## **Submission of Mosman Council regarding d'Albora Marina**

### **MP08 0046**

The comments of Mosman Council in respect of the proposal to carry out development at the d'Albora Marinas site at the Spit are outlined below. The format generally follows the structure of the Director General's Requirements and includes other matters raised in Council's consideration of the material submitted in support of the proposal and from Council's knowledge of the area.

Figure 2-1 Proposed Alterations & Additions

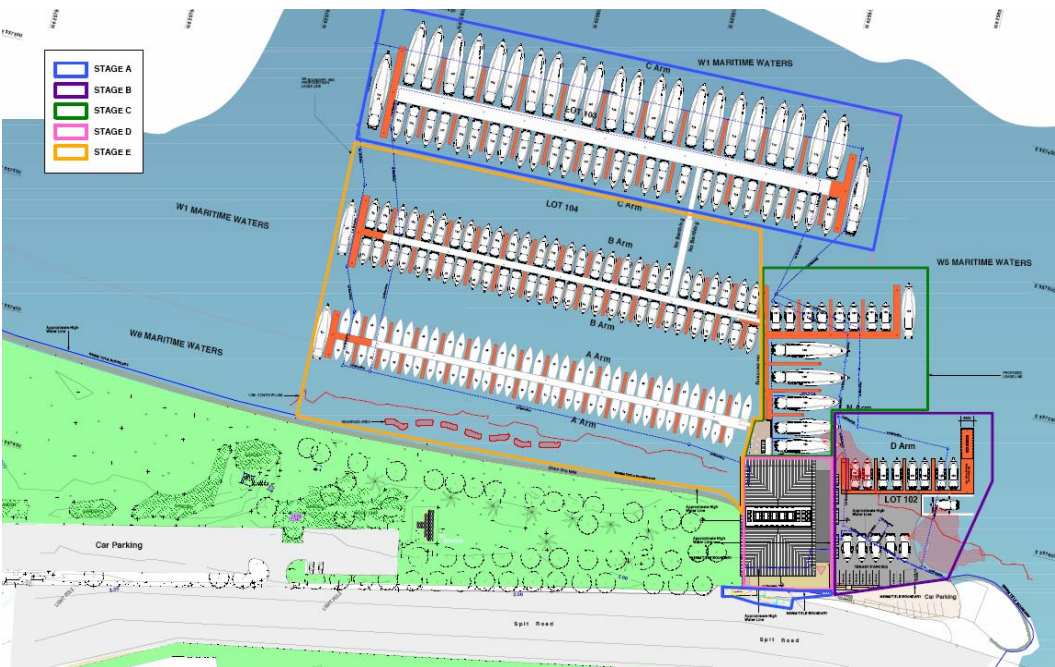
The proposed marina building comprises a large 32mx22m rectangular two-storey form with overhanging, relatively flat roof. It is a free standing, self-referential building that relies for its contextual fit on the large visual catchment afforded by the waterway and reserve lands.

The building has no regard for the architectural form and detail of traditional waterfront marine uses as typified by waterfront development on the eastern side of Spit Road (notably Ferguson's Boatshed). It appears to have been designed to maximise its volume on the site. The designation of substantial floor space, particularly on the first floor level to offices is atypical of usual water-

An alternative approach to the design of a building could include a more traditionally proportioned marina complex of relatively discrete buildings up to two storeys in height. Such an approach could achieve a development of equal functionality, greater permeability and lesser presence in this visually sensitive locality. Approval of the building in its present form therefore is opposed and a revision addressing the above issues should be required.

From what can be seen from the application plans both pedestrians and cyclists would need to cross the enlarged entry apron to proceed to Spit West pathways or under the bridge to Spit East. As presented this would not be appropriate or adequate and should be resolved as a precondition of any new building work on the site. Council's study provides an opportunity in this respect.

It is also not clear whether the indented manoeuvring bay is intended to serve as a set down and pick up area for visitors to the site as the boardwalk on the southern side of the building discharges directly onto the roadway in the indented bay. If the area was used by boat crews to unload stores or equipment to transfer to moored vessels further issues of conflict would occur. This too suggests that a more thorough approach to the design of the land-based components of the site is required.

extent possible. Cycle and pedestrian access would be interrupted and the junction of the path and the indented vehicle manoeuvring area is not resolved in a satisfactory manner. Pedestrian and cyclist safety in this location is a significant issue in need of resolution.

The relationship of the moored boats, particularly in the extended Arm A may also be a matter of concern due to the limited manoeuvring space between the seawall and the marina. The plans still do not identify the new sea wall and viewing platform which is regularly used for fishing and even with the current configuration has led to conflicts, including claims of fishermen casting lures on to passing vessels, etc.
